Tween Bridge Solar Farm

9.10 Statement of Common Ground with National Highways

Document Reference: 9.10

Revision 2

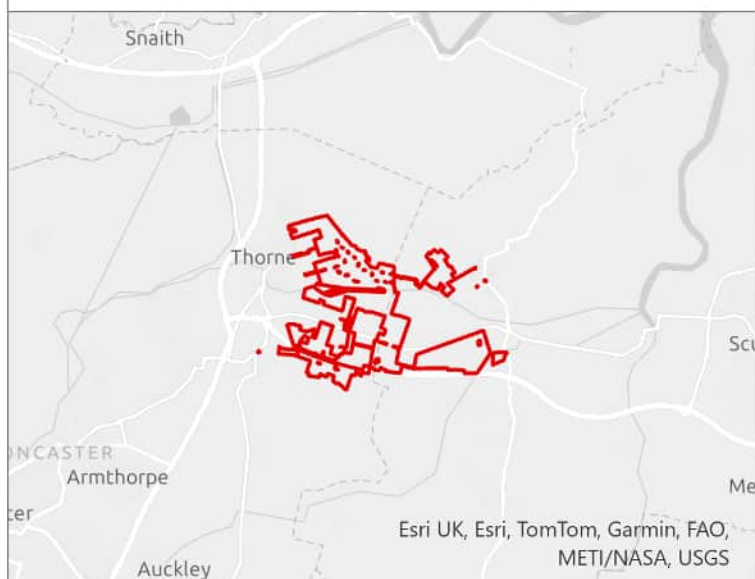
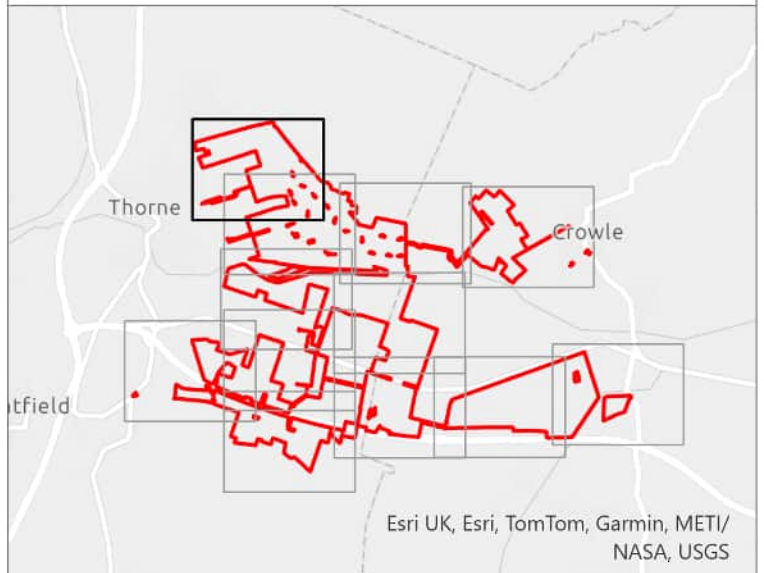
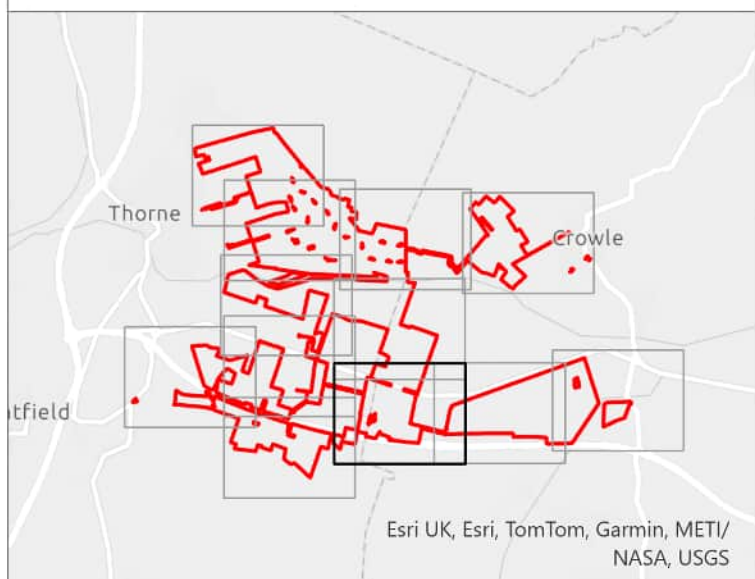
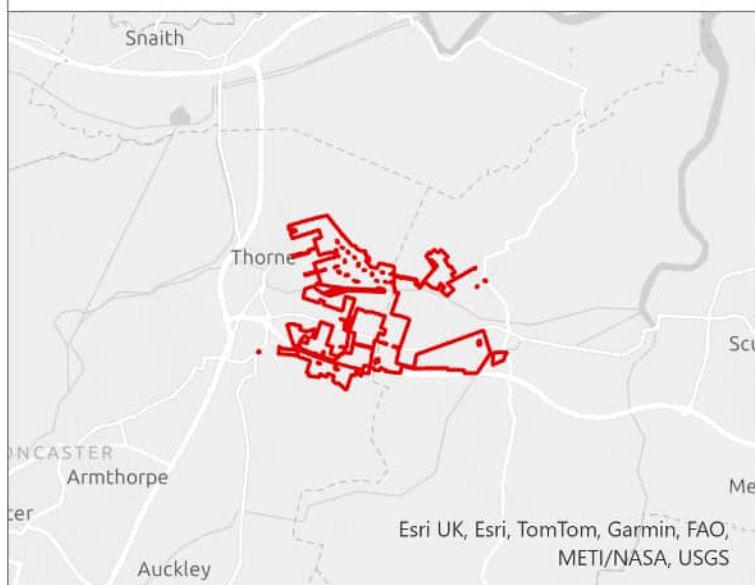
<p>The Applicant's outline indicative layout plans [APP-134 & 135] demonstrate the extent of fencing and enclosures bounding the SRN (for example, see field references D2, D6, D3, D5, D10, D11, D12, D13 etc). Fencing adjacent to the SRN must be designed in accordance with the Design Manual for Roads and Bridges (DMRB) in order to achieve the necessary safety standards, without which pose unacceptable risk to road users.</p> <p>NH requires the following amendment to Requirement 9 in order to ensure the necessary temporary and permanent fencing meets the required design standards:</p> <p><i>9(1) No phase of the authorised development may commence until written details of all proposed temporary fences, walls or other means of enclosure, including those set out in the outline construction environmental management plan, for that phase have been submitted to and approved by the relevant planning authority or both relevant planning authorities (as applicable) or National Highways in respect of fencing to be erected adjacent to the strategic road network.</i></p> <p><i>9(2) No phase of the authorised development may commence until written details of all permanent fences, walls or other means of</i></p>
